Demolition of existing garage & outbuildings. Alterations to external materials (including change from thatch to clay tiled roof and brick/stone to fibre cement weatherboarding and coloured render). Alterations to existing fenestration, including to 2 no. ground floor rear bay windows, and addition of first floor front dormer, enlarged balcony at first floor level at the rear. Replacement garages.

The Breakers 29 Tamarisk Way East Preston

Thank you for your internet representation made on 21st January 2020 which has been recorded as '**an objection**' with the comments as follows:

1:100 West Elevation

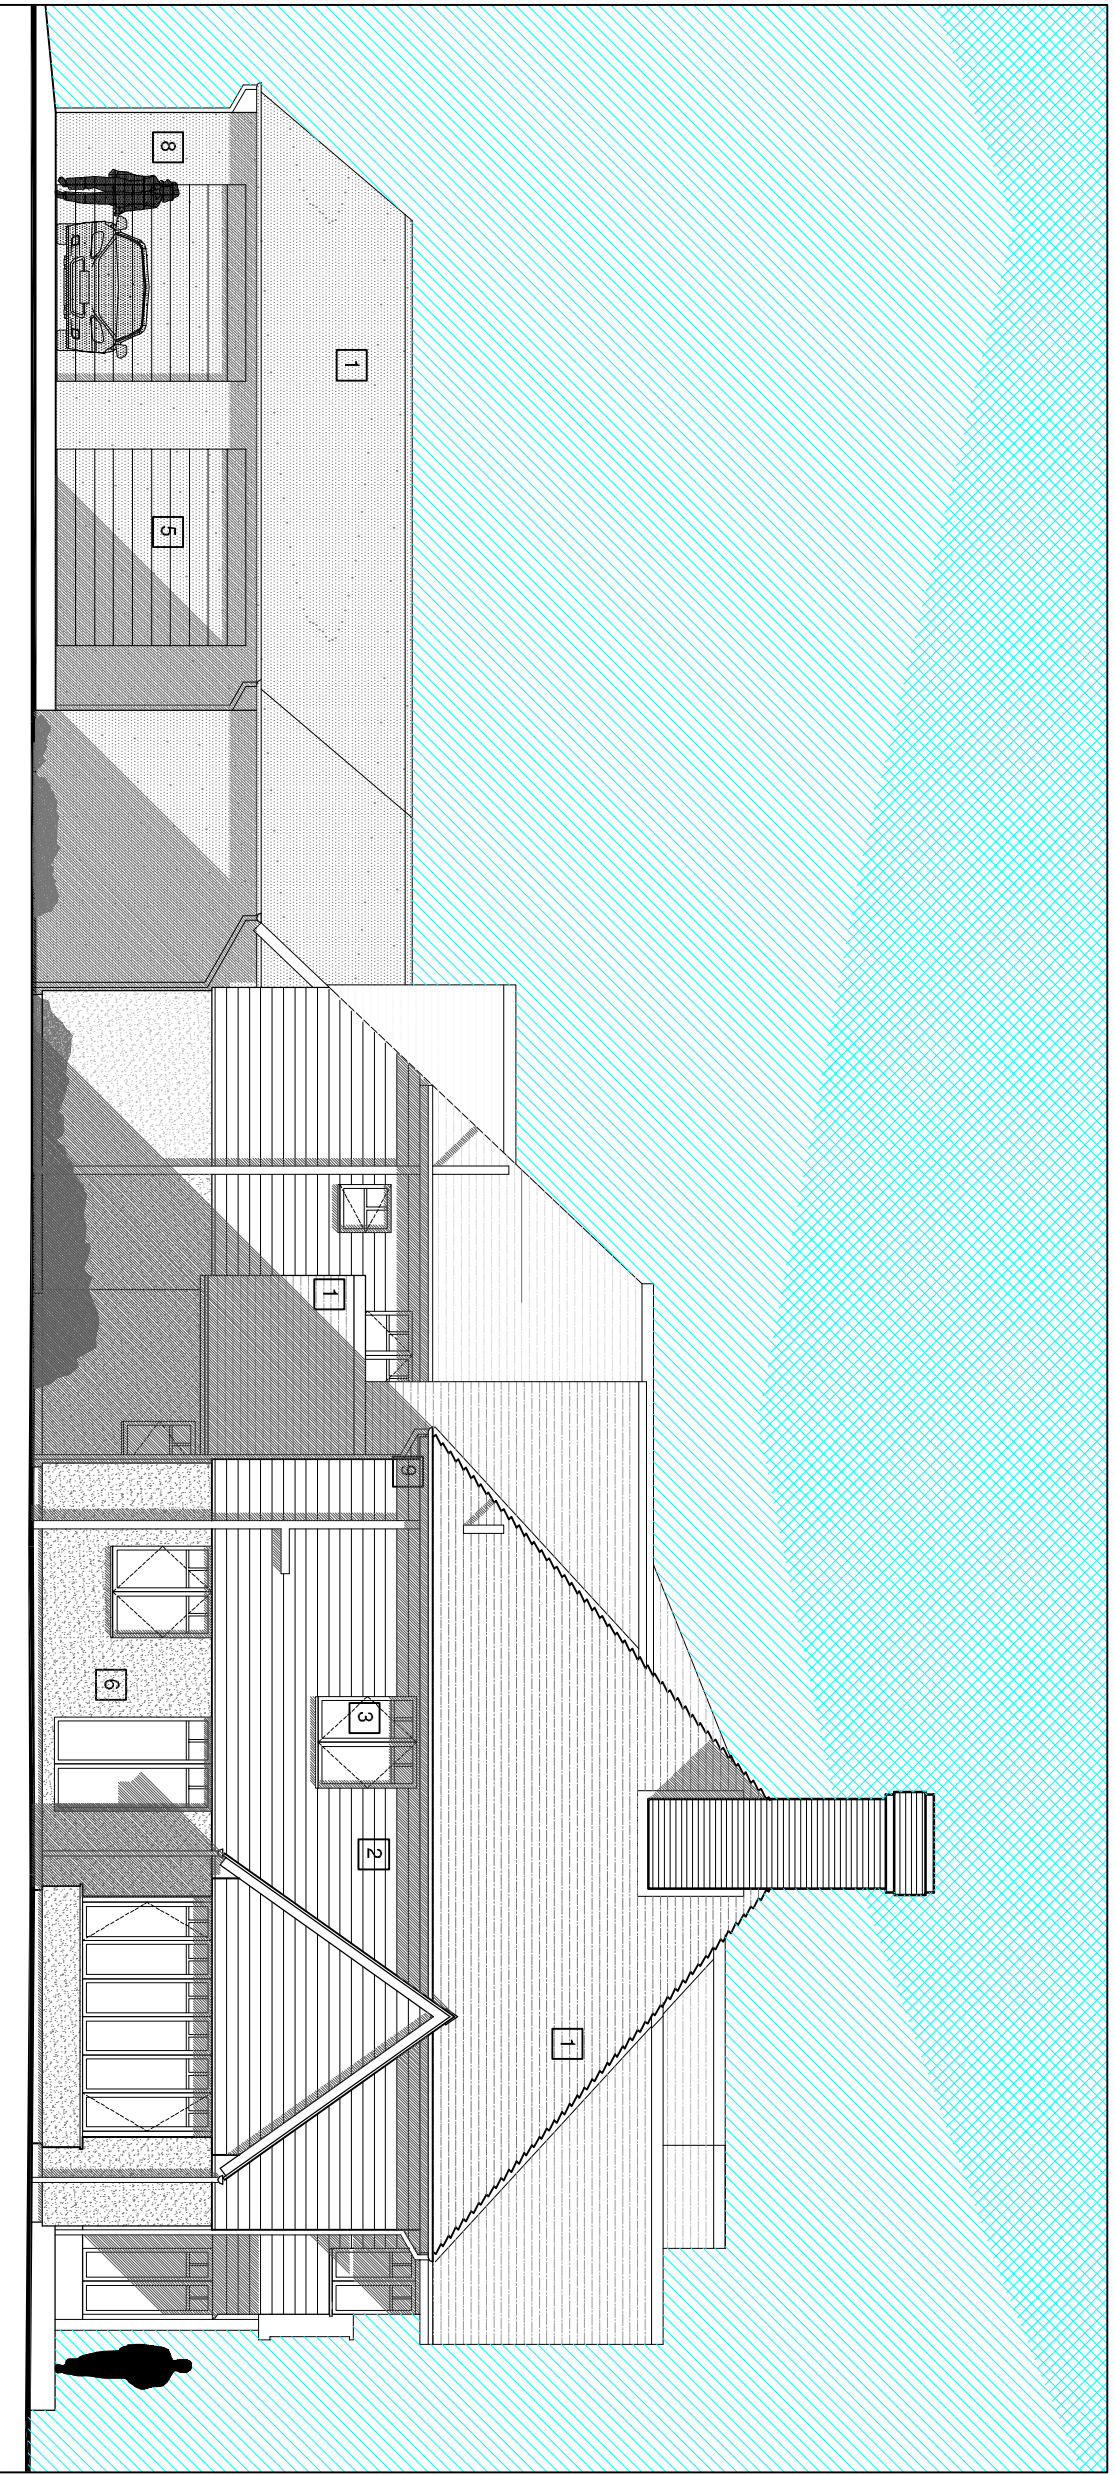
Sad to see the new owner of Breakers wanting to change the house so much, the Thatched roof is magnificent it would be a great shame to change to tiles, The wall looks to be quite tall, altering the appearance of such a lovely home.
